STAGE 1 & 2 ROAD SAFETY AUDIT

SECTION 278 ACCESS WORKS, FIELD HEAD LANE, BIRSTALL

Job Number	26019
Filename	Field Head Lane Stage 1 & 2 RSA
Issue No	2
Issue Date	11 th March 2026
Author	Tom Lyons
Reviewer	Chris Yarrow

No.	Revision	Date	Drwn
Status			
Client STONEWATER			
Project FIELD HEAD LANE BIRSTALL			
Drawing title S278 VEHICLE SWEEP PATH TRACKING			
Drawn RT	Chkd AD	Date SEPT 25	Scale 1:100
Contract No. 25469	Drw No. DR-C-0136-2	Revision	P2

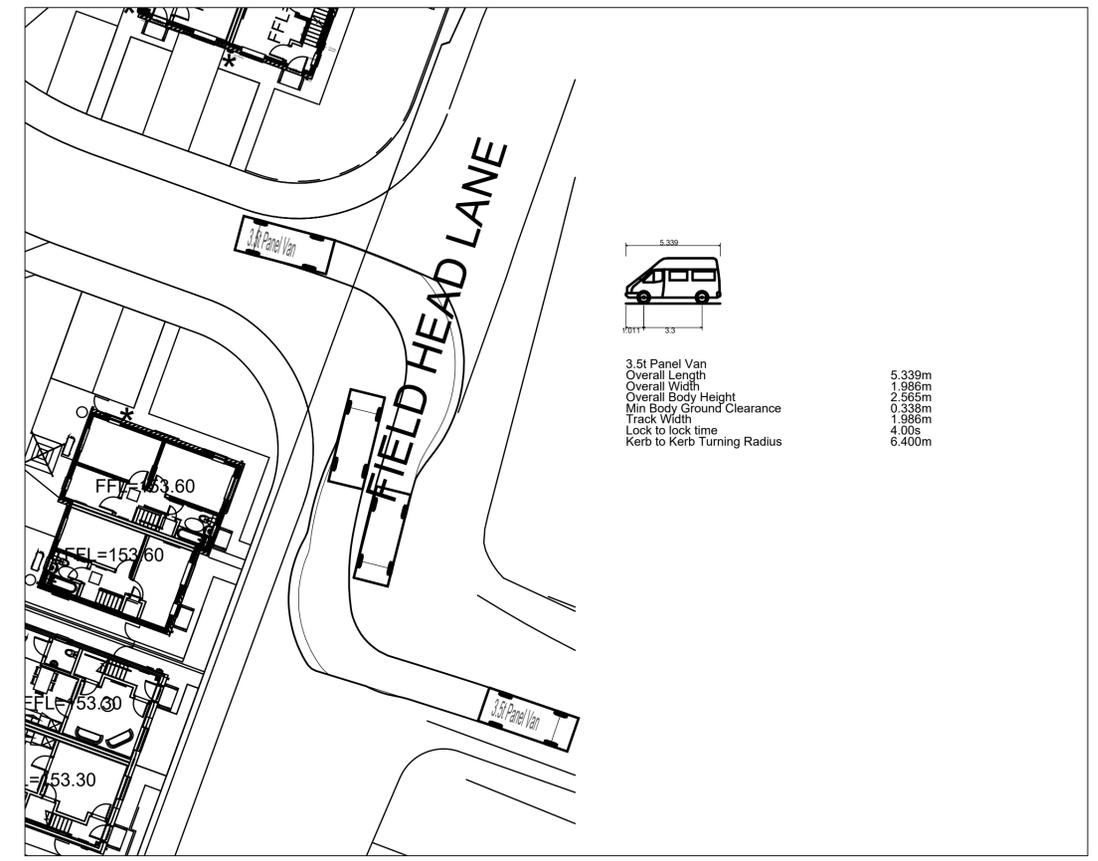
Problem 1	
Location	Site access off Field Head Lane.
Summary	It is not clear if the tracking analysis demonstrates that there is sufficient carriageway available at the junction.
<p>It is not clear if there will be sufficient carriageway available to accommodate vehicle turning movements at the junction, particularly for large vehicles, if vehicles are parked directly opposite the junction on the east side of Field Head Lane. This will result in vehicles riding onto the footpaths and at risk of conflicting with pedestrians.</p>	
Recommendation	
<p>It is recommended that the designers ensure that there is sufficient carriageway and or waiting restrictions (yellow lines) provided at the junction to the site, to accommodate all vehicle turning movements on and off Field Head Lane, particularly when vehicles are parked on the east side of Field Head Lane.</p>

DART have undertaken tracking as shown on drawing 25469-DR-C-0136 P2 S278 Vehicle Swept Path Tracking
